15, Hazel Avenue

01-12-20

Having looked at the plans again, photographed and enlarged them, I notice that the rear upper bedroom has French doors and a leaning rail. I think this is known as a "take in the view spot".

**REAR WEST ELEVATION**  
PROPOSED - SCALE 1:50

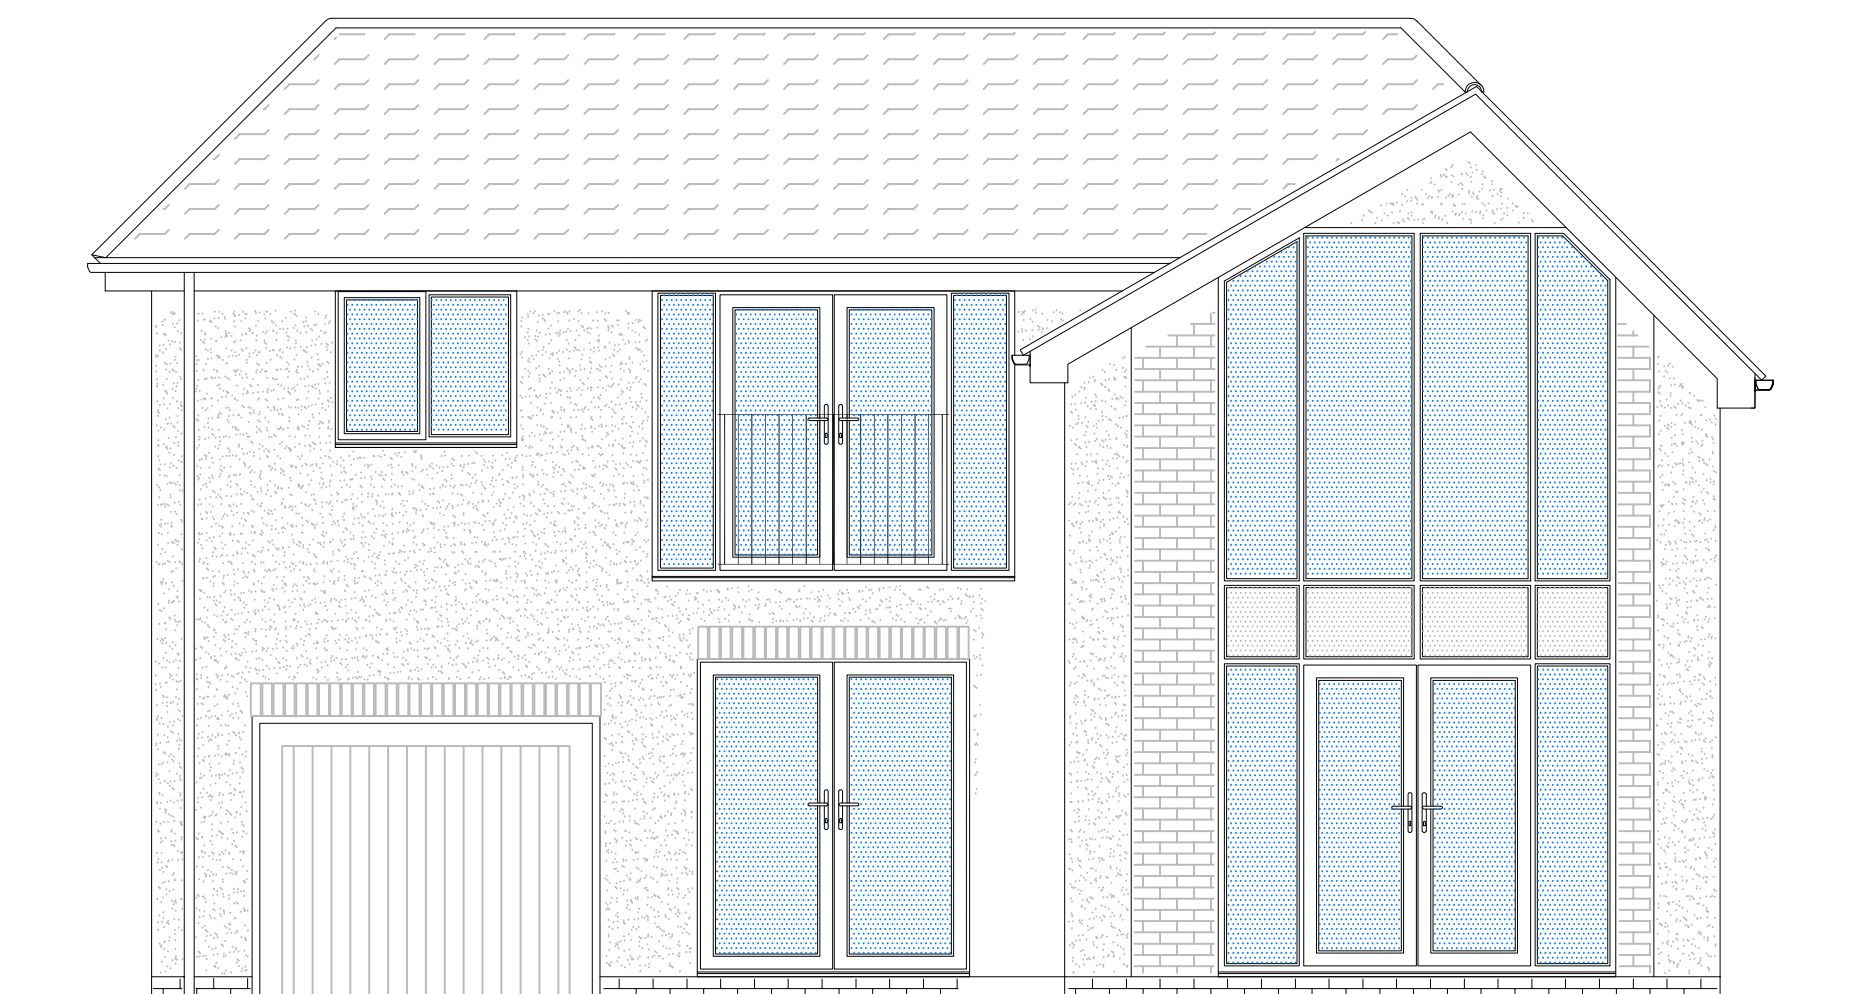
Please consider how much of my garden, [private space] has the potential to be overlooked.
